Site Location/Project: 90-102 Regent Street, Redfern, NSW

Our Ref: 210527_90-102 Regent St_Ad

Addendum to Arboricultural Impact Assessment Report (AIA) dated 29 September 2020

This document has been prepared to provide supplementary comments to the report prepared for the site, dated 29 September 2020, in response to comments raised by the City of Sydney Council.

GROUND LEVEL | PUBLIC DOMAIN LANDSCAPE PLAN

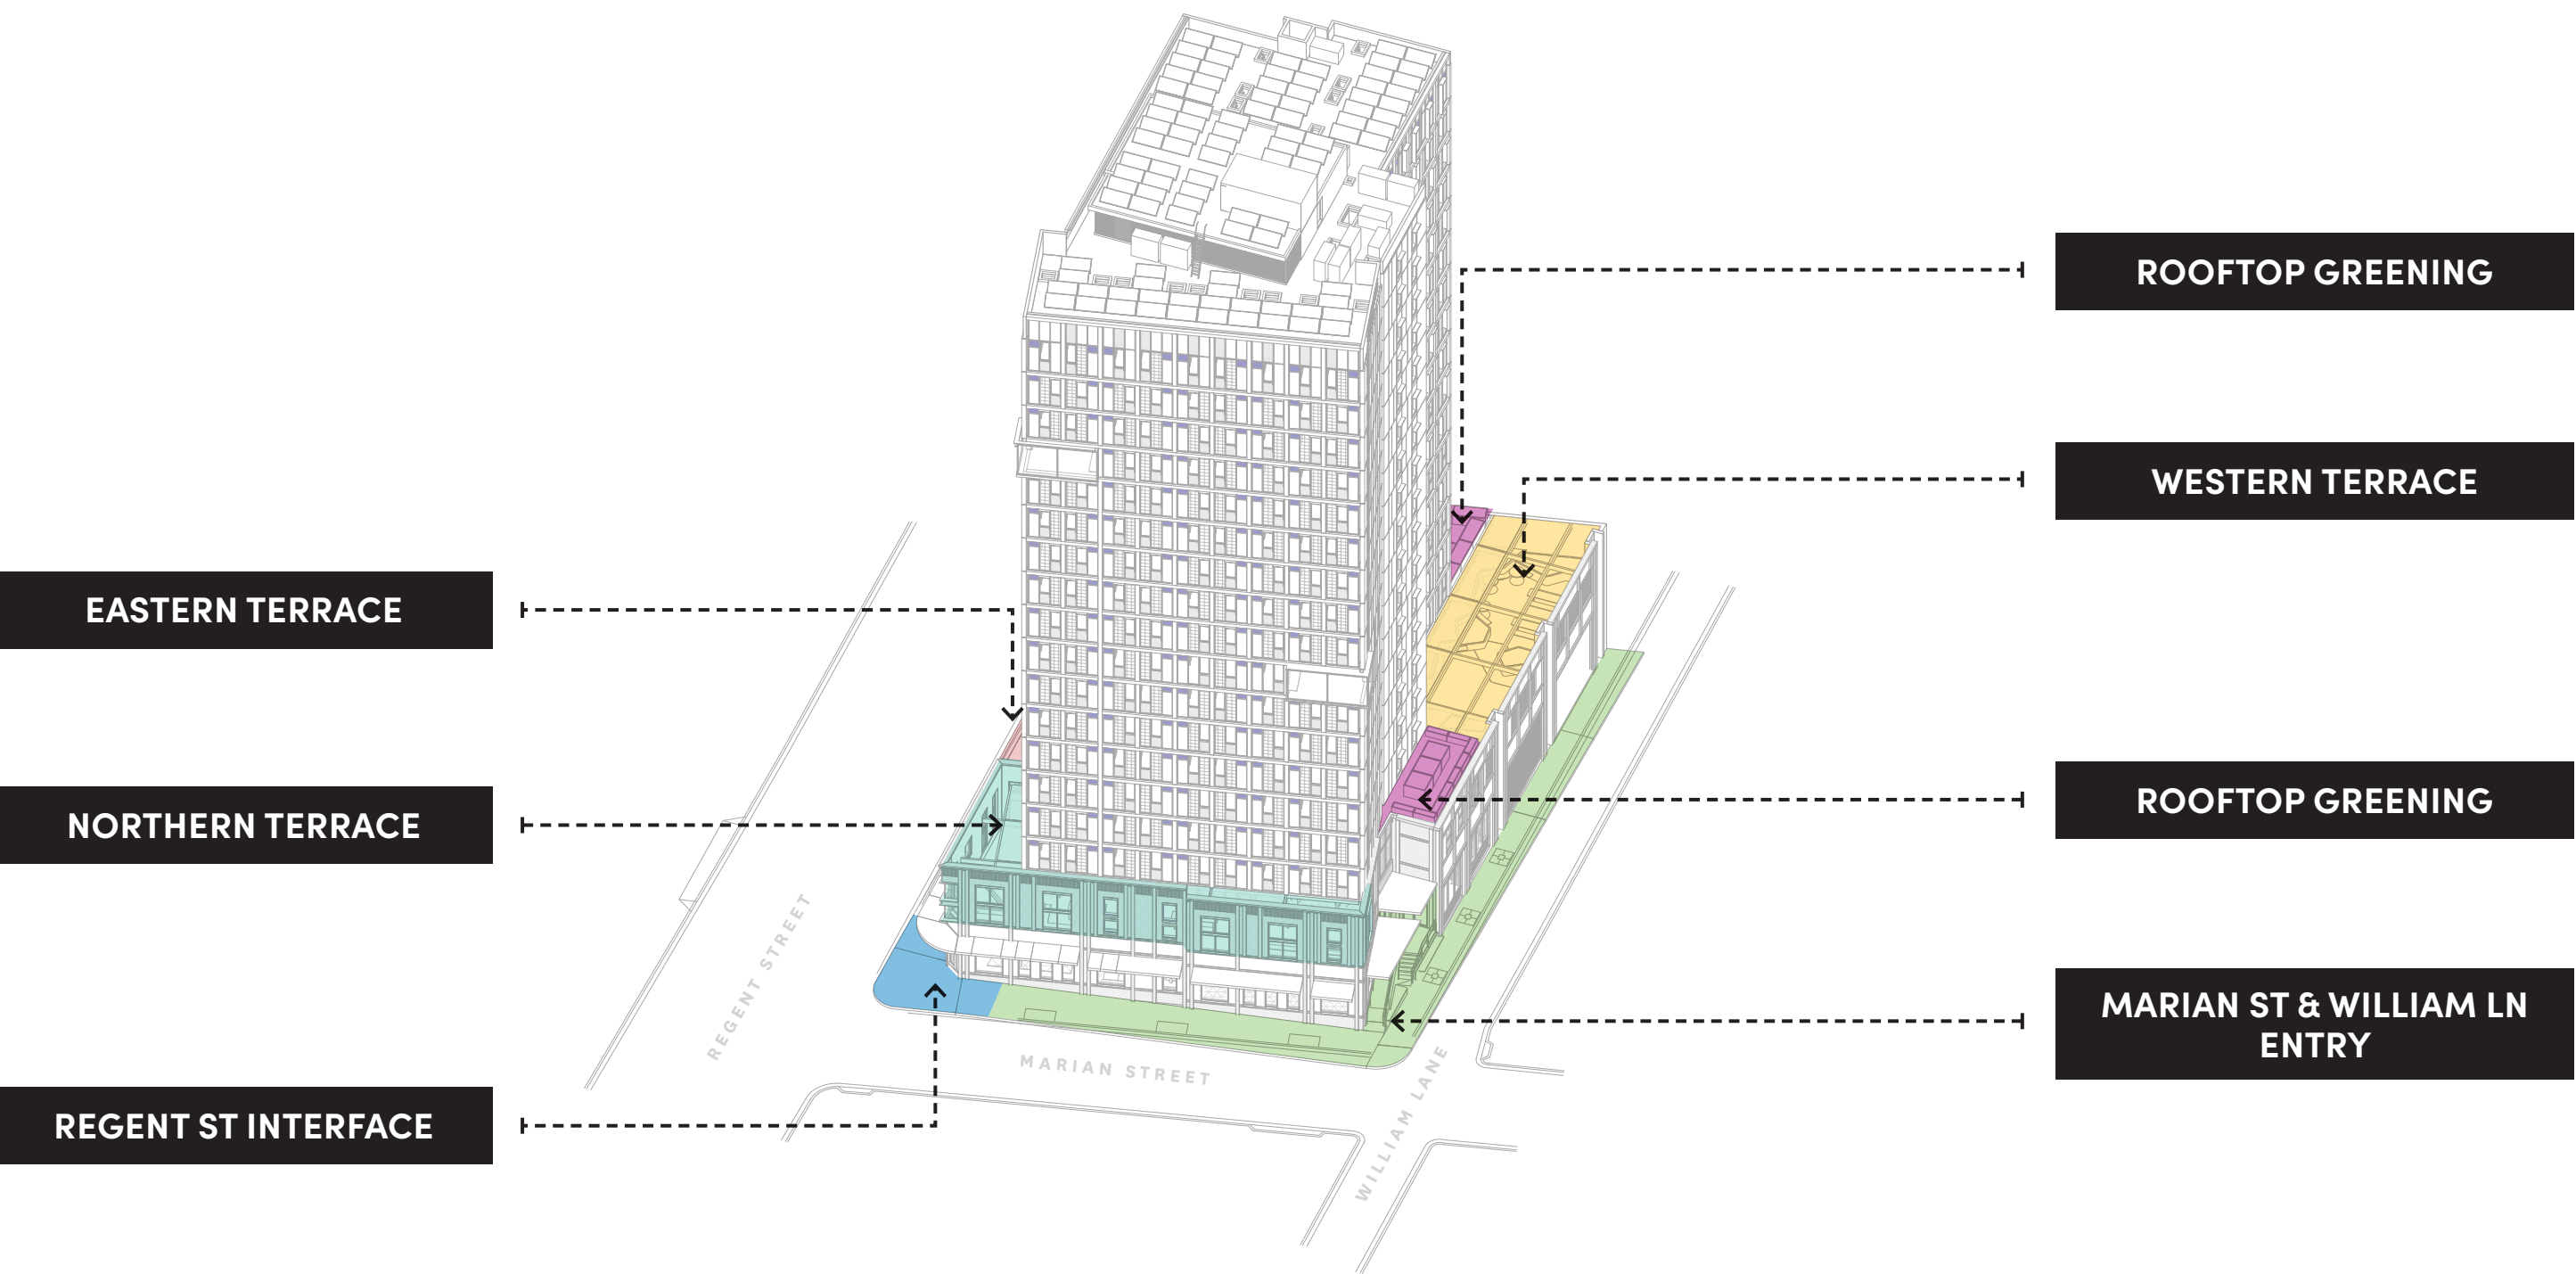
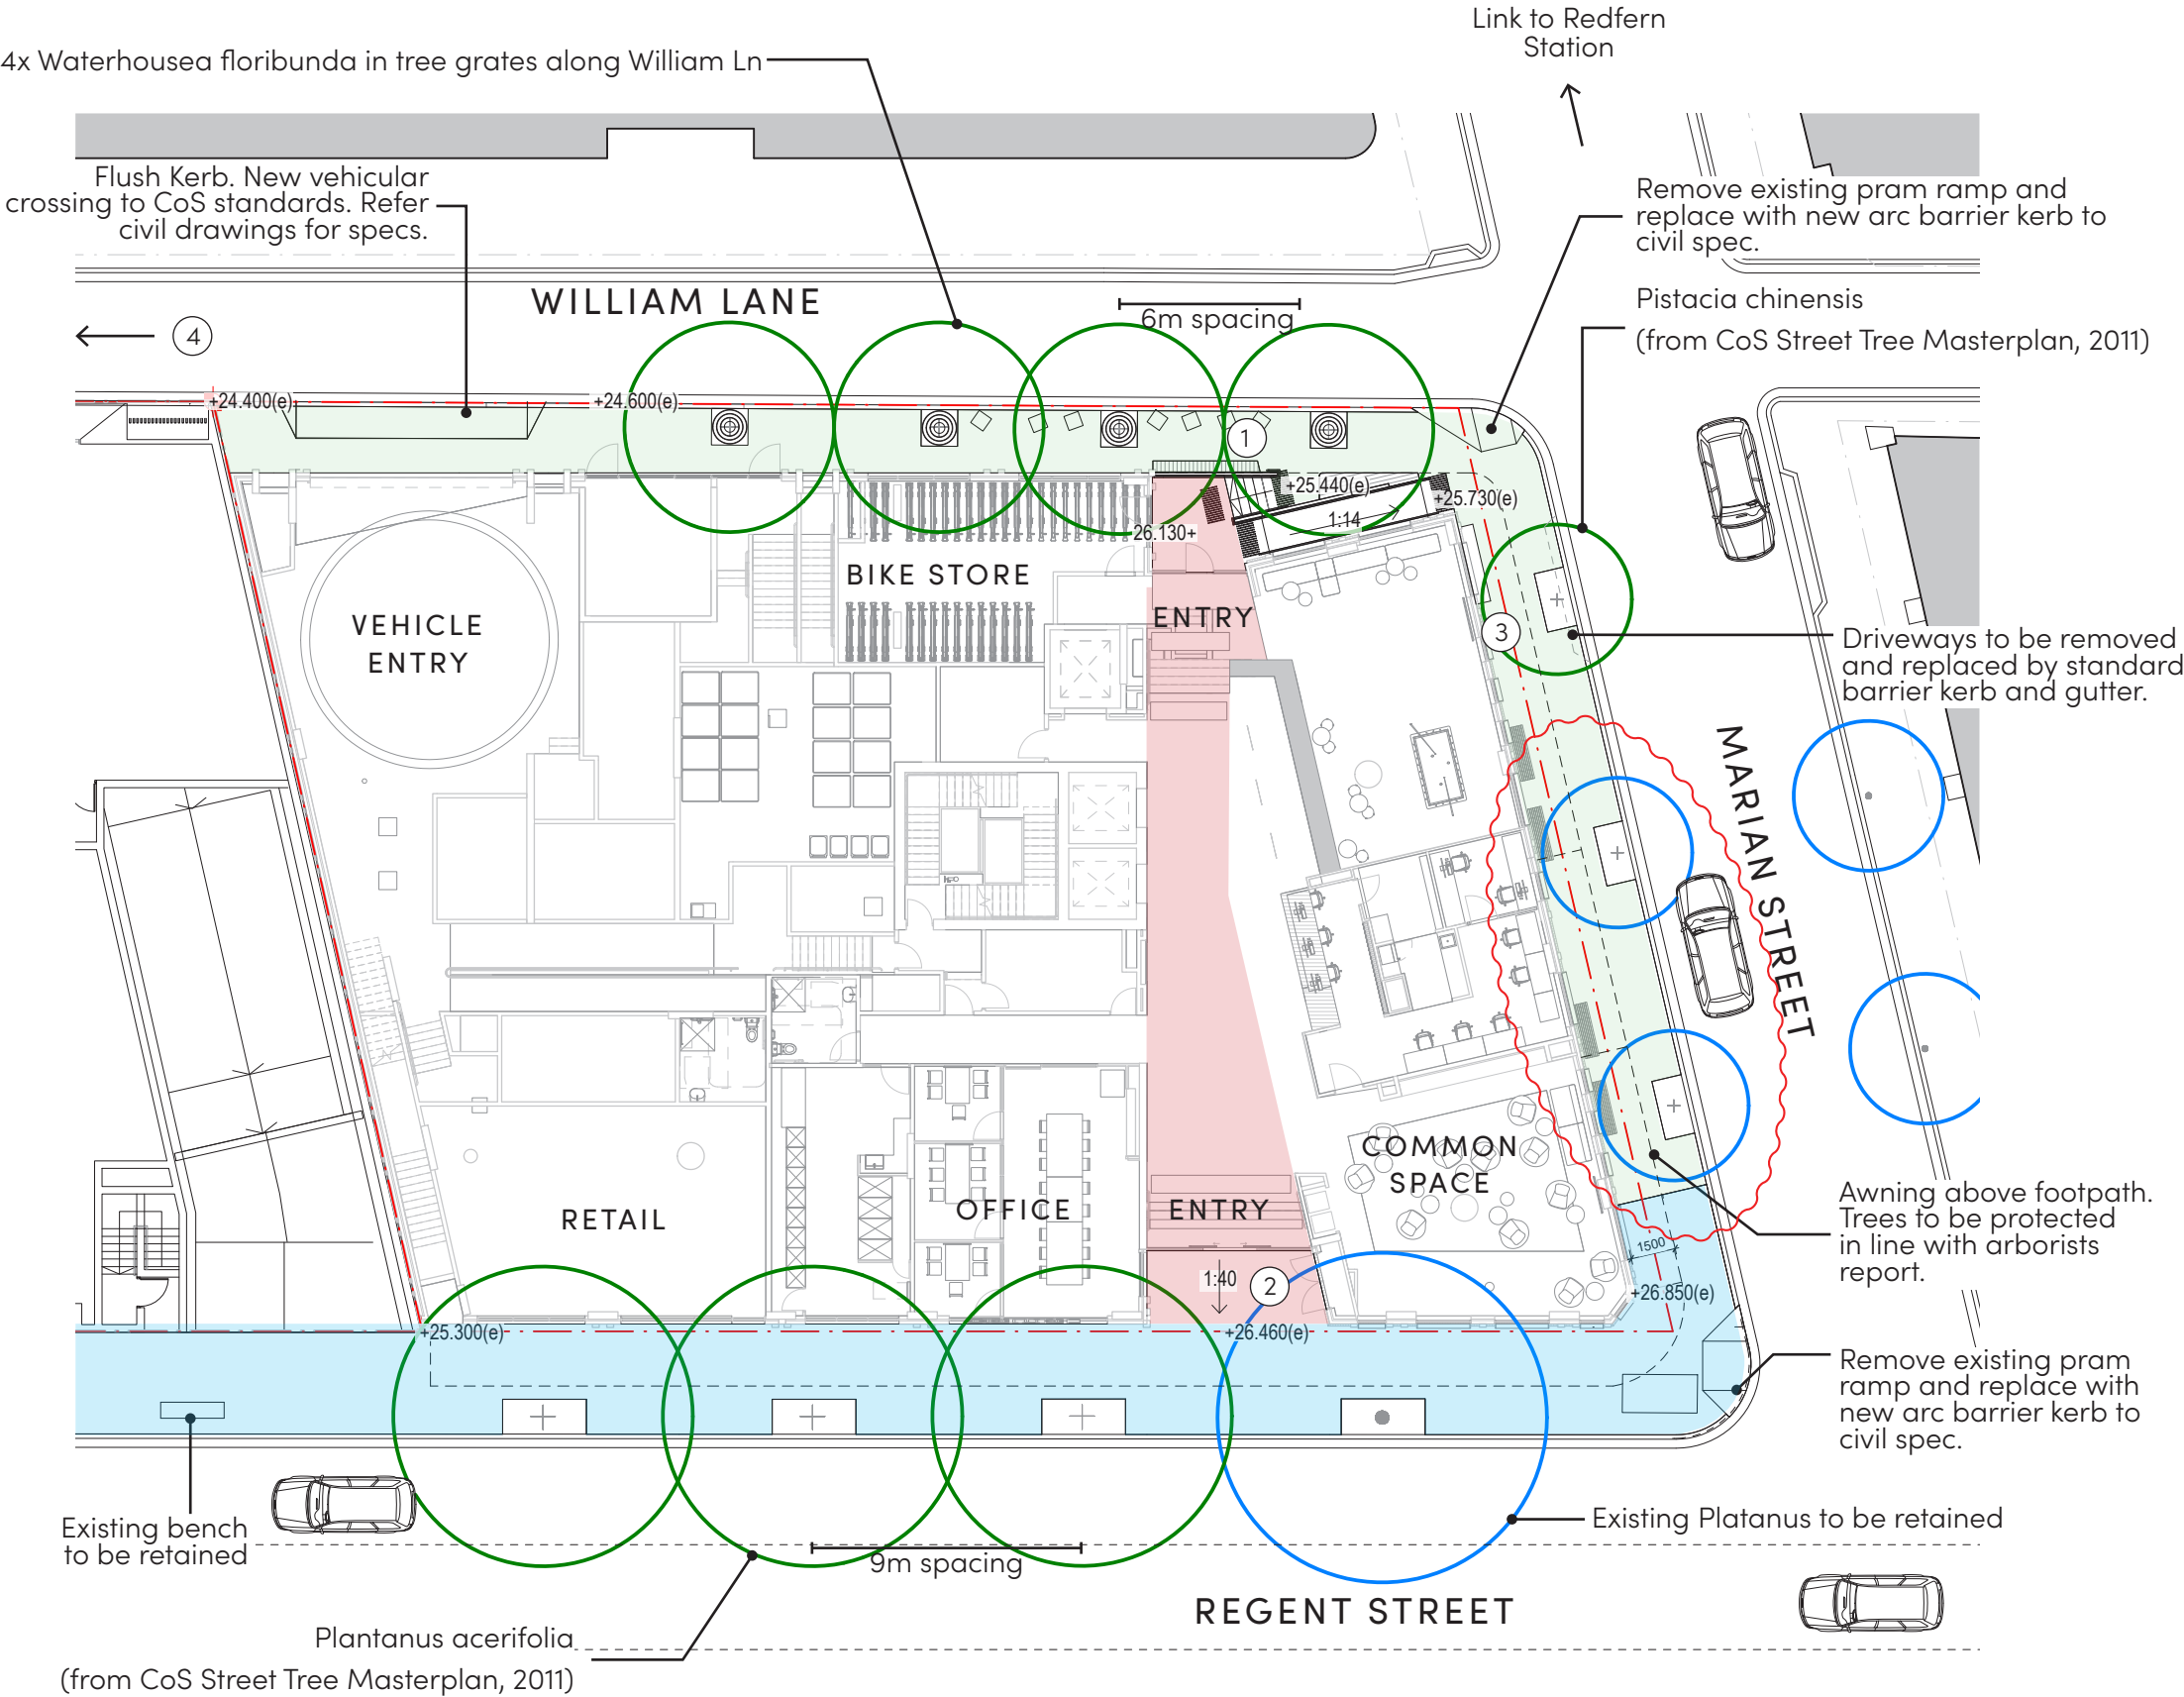
Item 2: Awning is too high to provide effective weather protection from rain, sun and wind and should be simple box awning without cut outs for street trees to both Regent and Marian Streets and consistent with the requirements of Section 3.2.4 - Footpath Awnings of Sydney DCP 2012. Any signage is to be within the fascia of the awning.

Item 16: Design elements including awnings, street furniture, footpath upgrade within public domain must ensure appropriate setbacks are provided from existing street trees to allow maturity of the trees to be achieved.

Item 20: Awning design must be amended to provide adequate space and clearance for new street trees to grow without conflicting with the awning.

The awning height has been lowered to between 3.2m-4.2m to allow for the slope of Regent Street. The awning depth along Regent Street has been reduced from 2.8m to 2m.

Tree 1 is the only existing street tree at Regent Street adjacent to this awning, which is a Plane Tree (*Platanus x acerifolia*) that is semi mature in age class. Three new street trees are also proposed adjacent to the Regent Street awning. Canopy pruning for tree 1 will be required to accommodate the awning, the pruning will be required as per the specifications in section 9.2 of the AIA report. The pruning will not adversely impact the condition or amenity value of the tree and is therefore considered minor and acceptable.

Tree 1 is a Plane Tree (*Platanus x acerifolia*), the three new trees proposed at Regent Street are the same species, which is in accordance with City of Sydney Street Tree Masterplan 2011 of this section of Regent Street. The City of Sydney Street Tree Masterplan 2011 identifies that Plane Trees have an estimated mature height of 18-25m. The proposed height of the awning at Regent Street varies from 3.2-4.2m in height.

All three of the new trees at Regent Street can be formatively pruned in accordance with AS4373 Pruning of amenity trees (2007) to crown lift/modify the shape of the crown to remove/reduce lower branches below a height 3.2-4.2m (the height of the awning) to prevent branches conflicting with the awning in the future.

The public domain works at Regent Street, in the Tree Protection Zone (TPZ) of tree 1, include the removal of the existing surface and replacement with concrete unit paving. The public domain works at Miriam Street, in the TPZ of tree 2 and 3, include the removal of the existing surface and replacement with in-situ concrete paving. To minimise the impact to tree 1, 2, and 3, the construction of the new concrete paving on both streets must be carried out in accordance with Part D - Technical Guidelines of the City of Sydney Street Tree Masterplan 2011. All demolition and construction works must be carried out in accordance with AS4970 Protection of trees on development sites (2009), see section 11 of the AIA report for more information. Providing that the public domain upgrade works are carried out in accordance with these specifications, the trees will not be impacted development works.
